**From:** Planning  
**Subject:** FW: 3/2023/0390

**Subject:** 3/2023/0390

South Elevation (Side Elevation Plot 2)
1:50 Scale

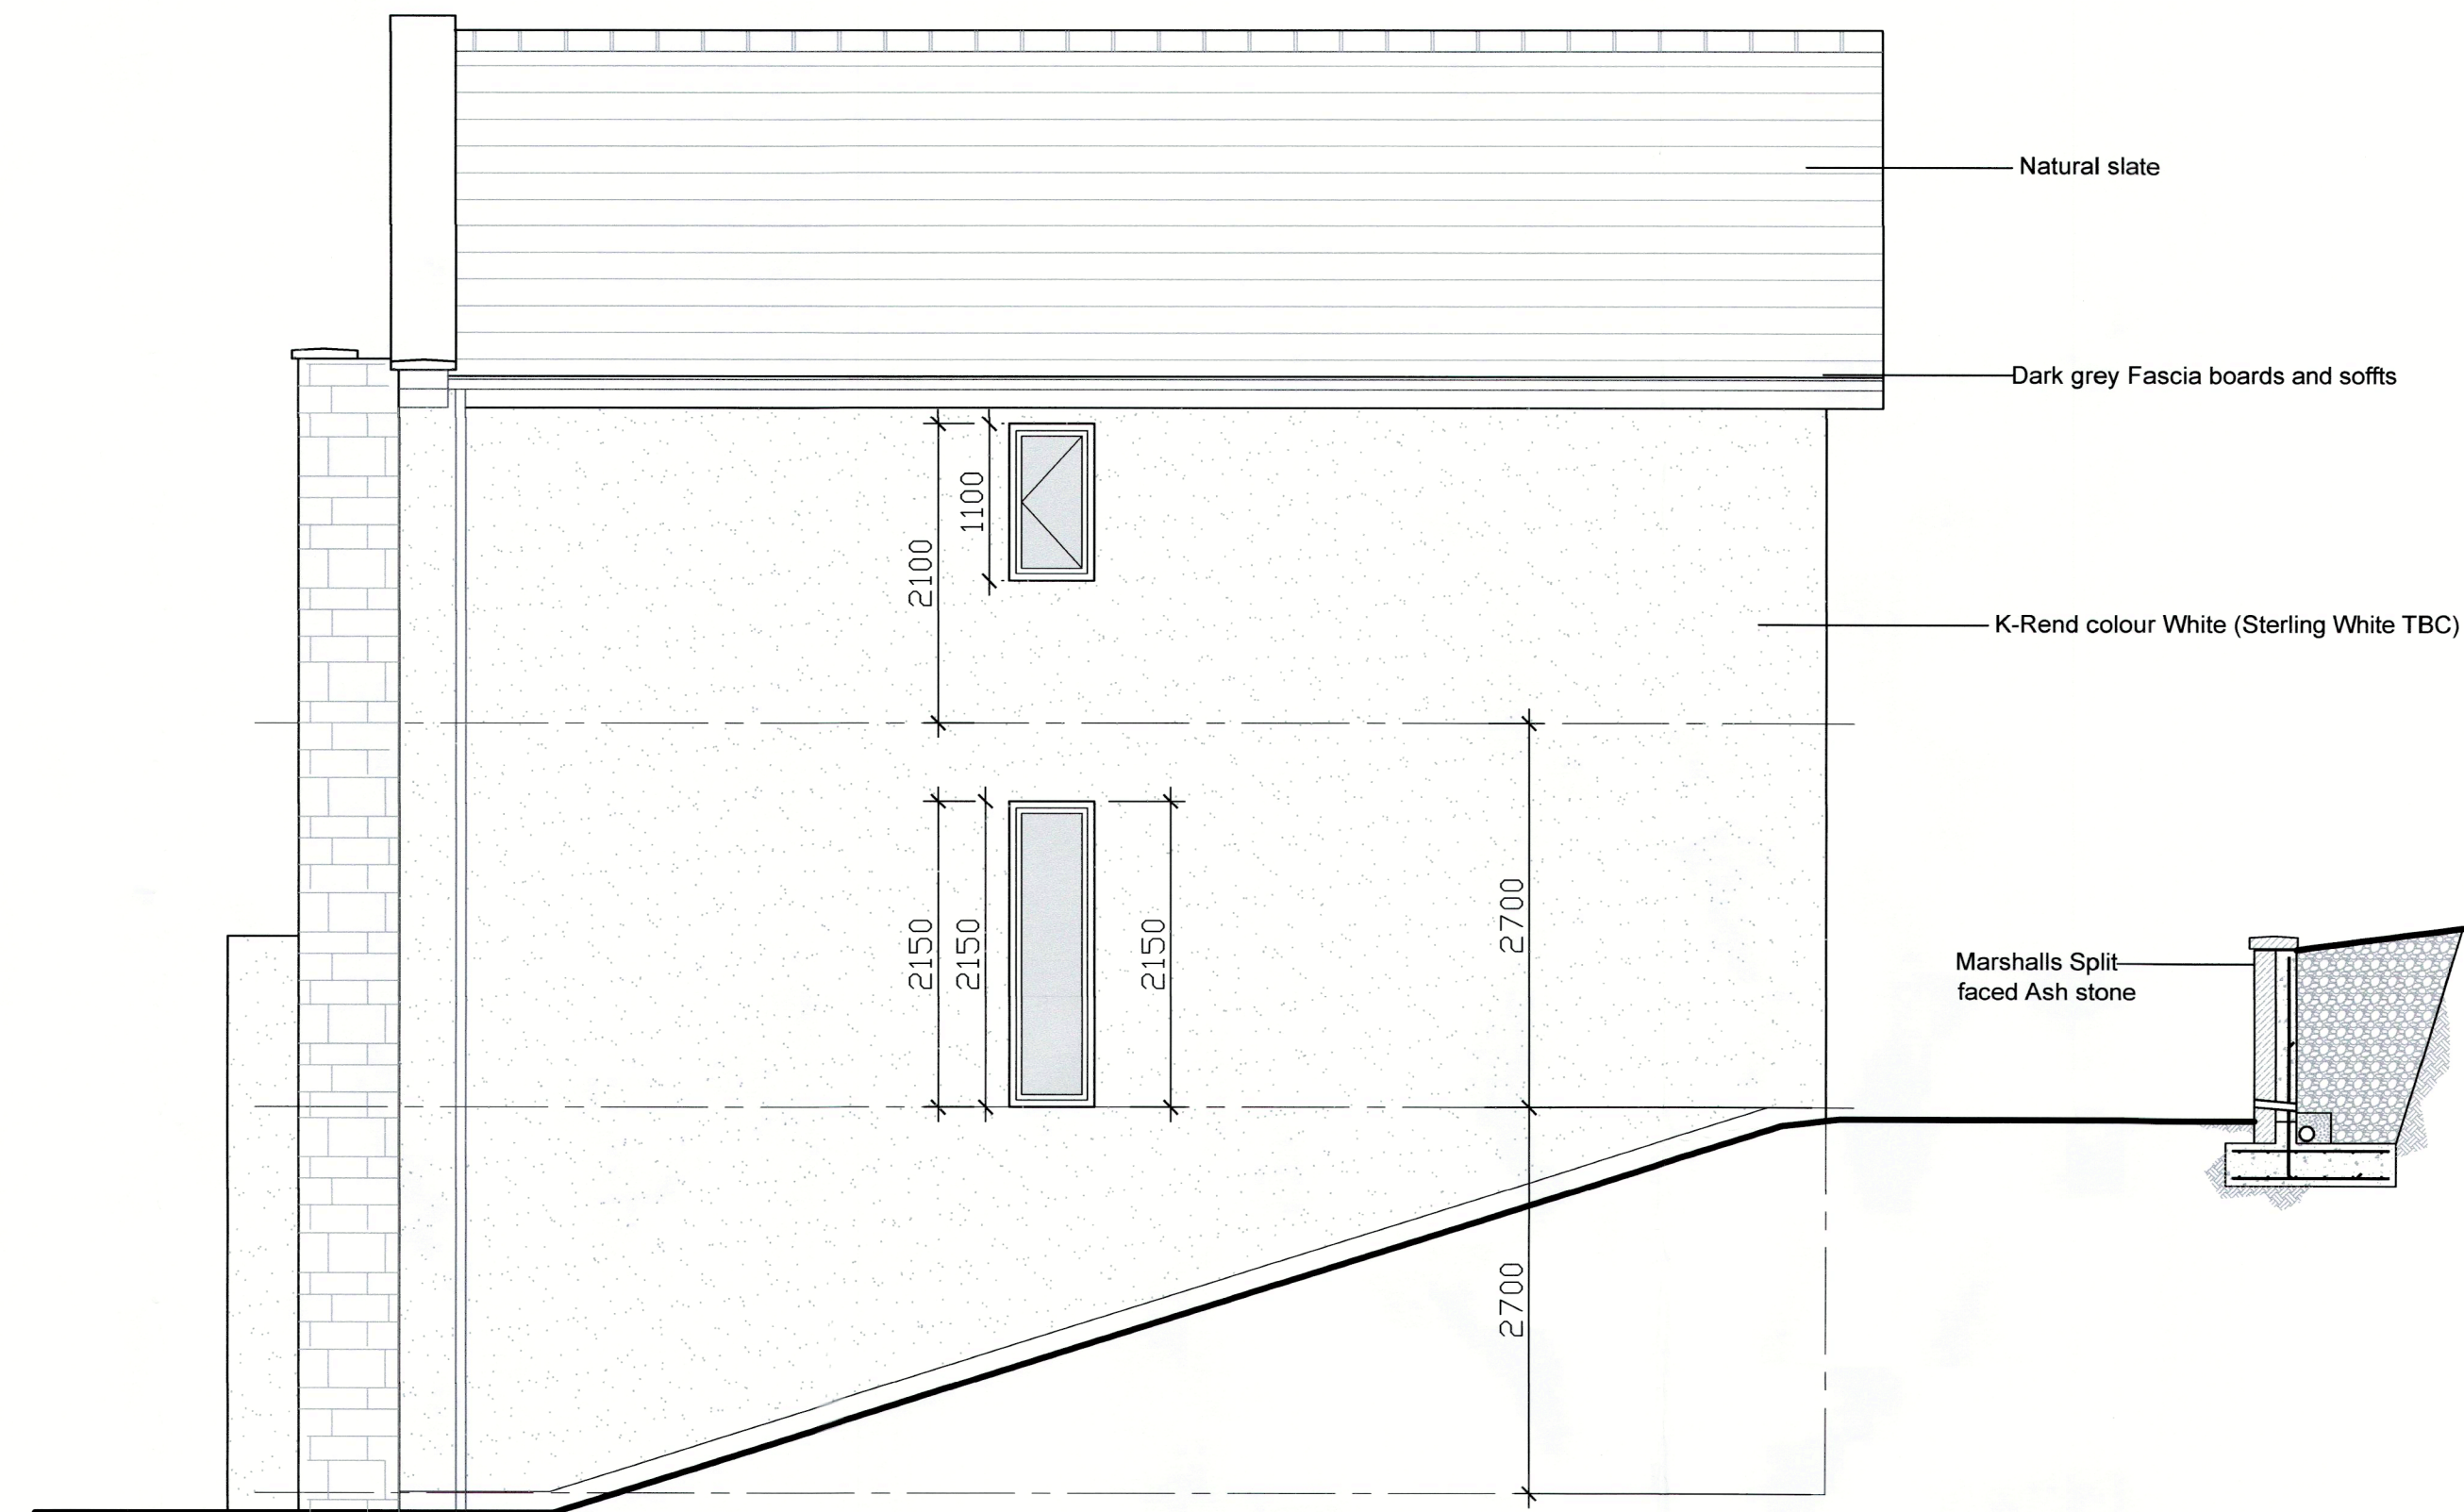
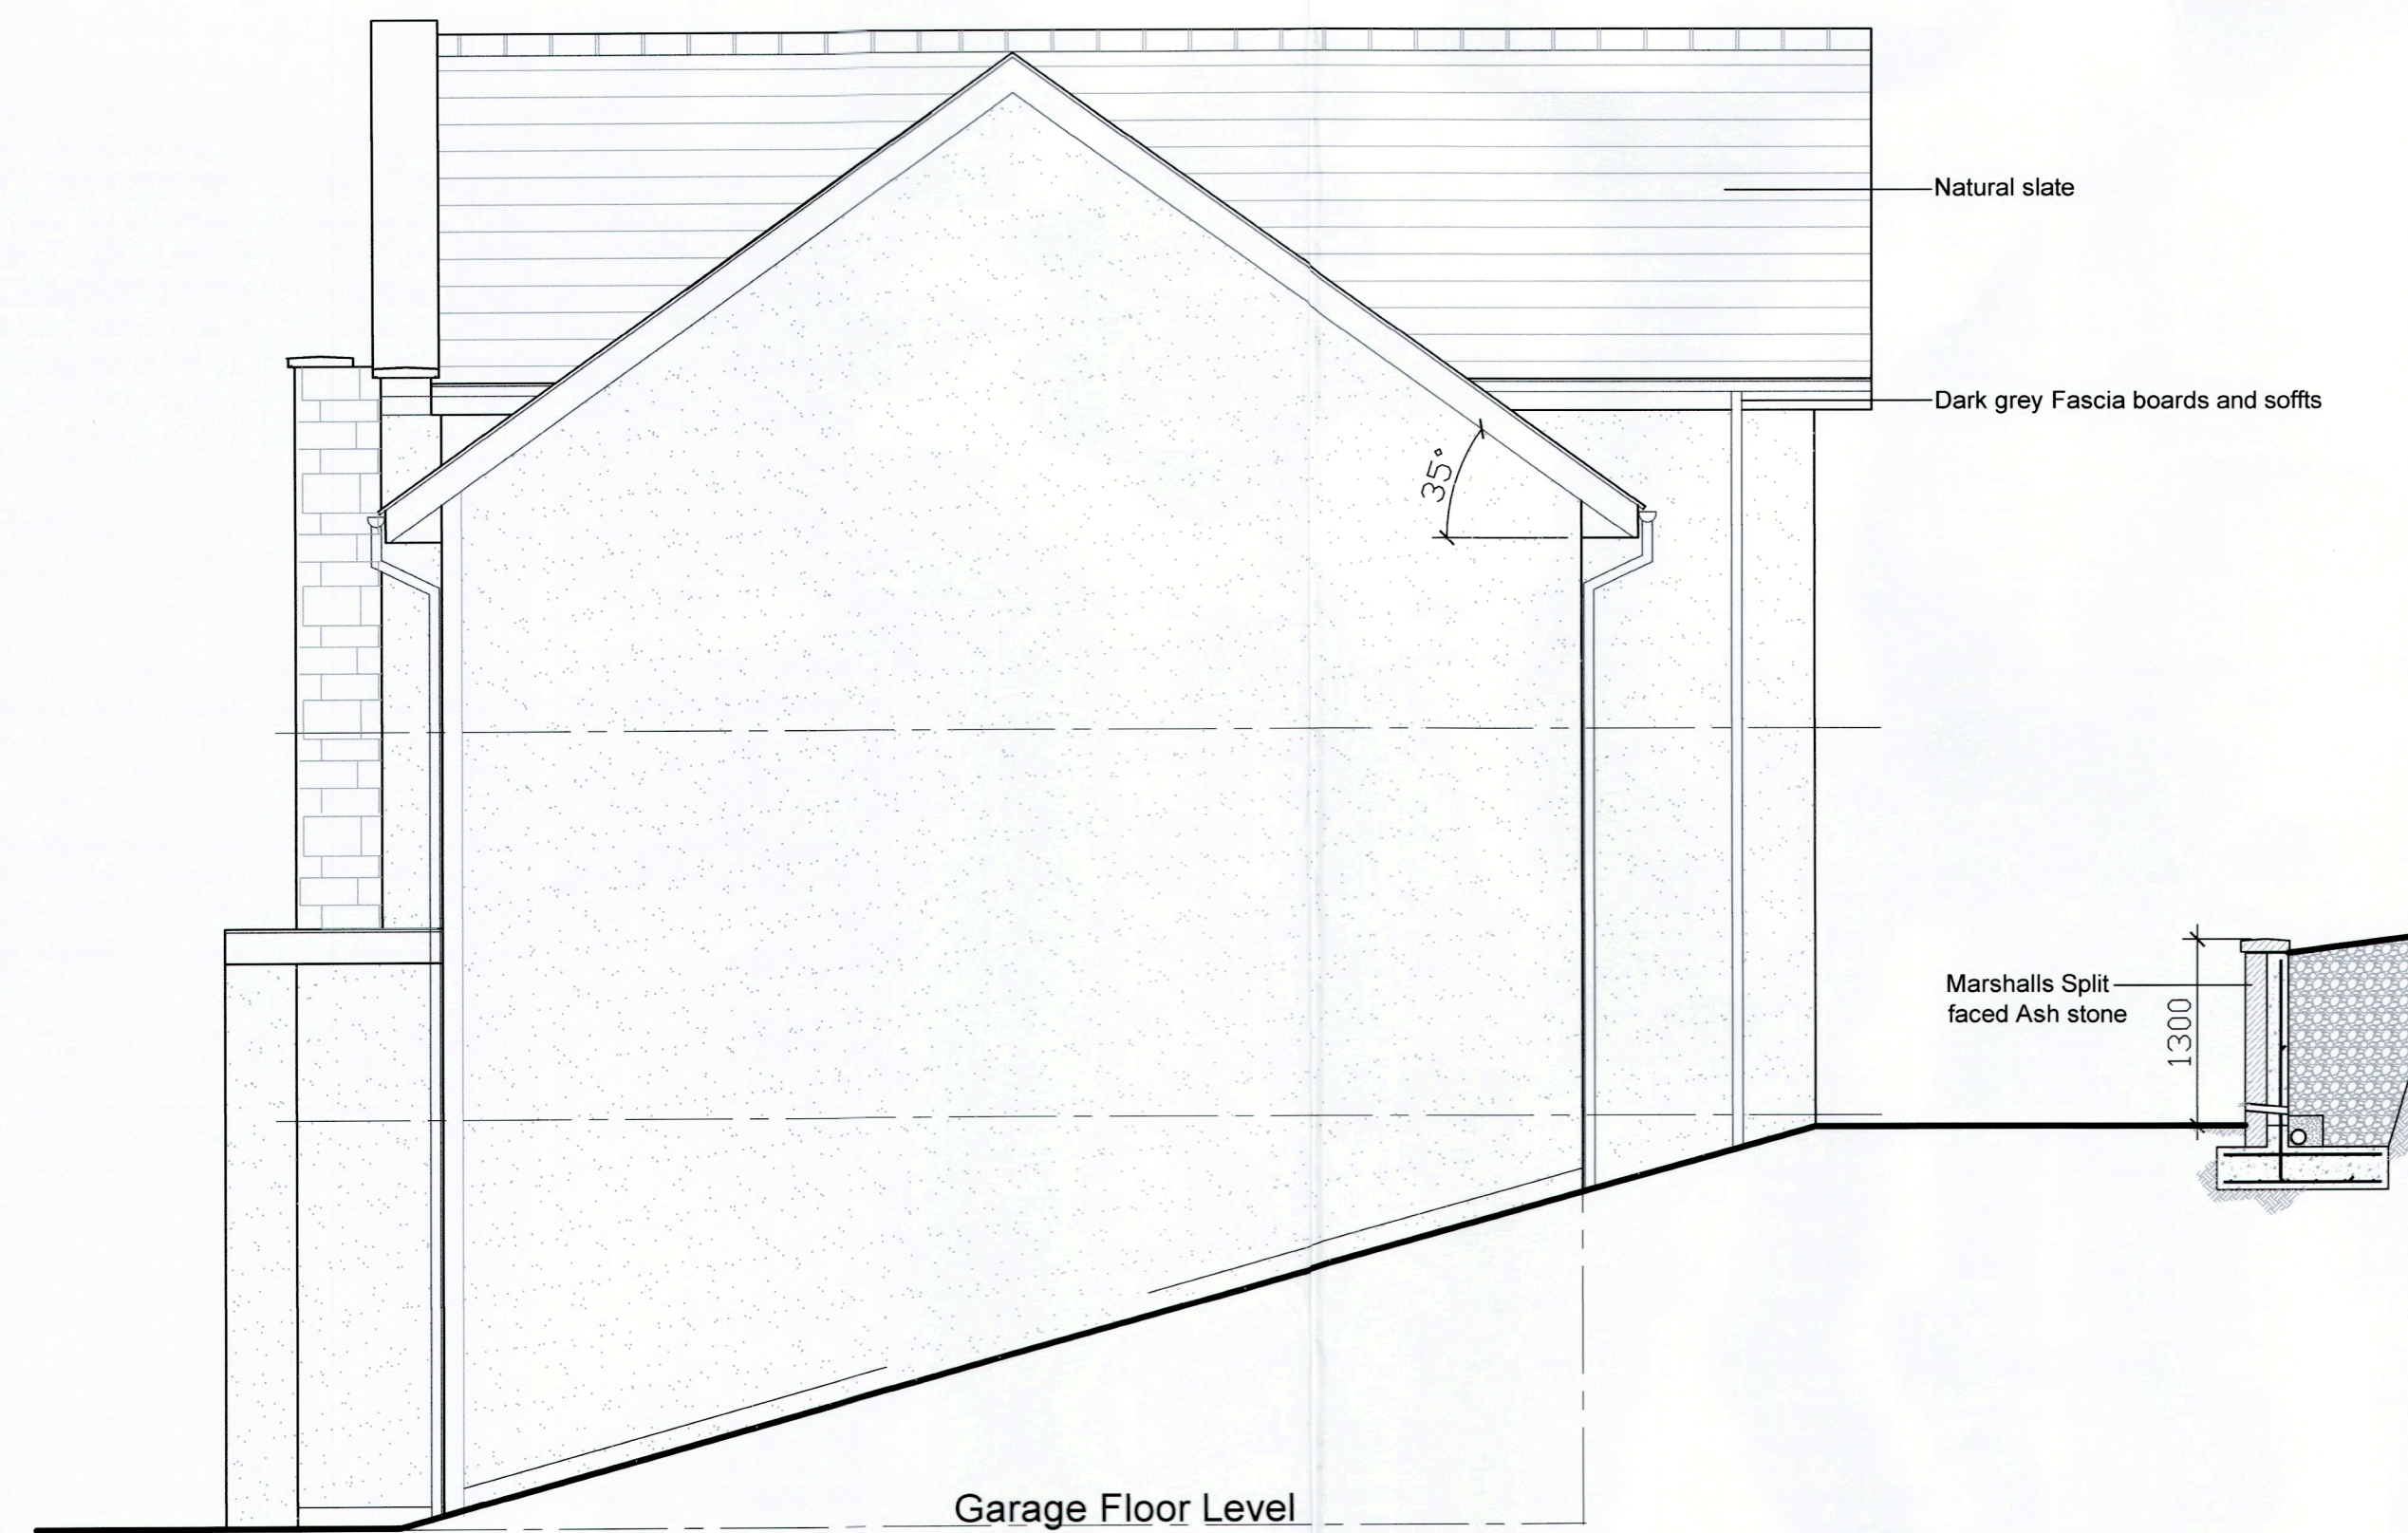
It does not explain or justify moving plot 2 backwards [REDACTED] The amended house details also extend the basement requiring digging deeper into the slope [REDACTED] The extra earthmoving will extend the build time and associated noise which is on top of the disturbance [REDACTED] just to get to the landform you see today
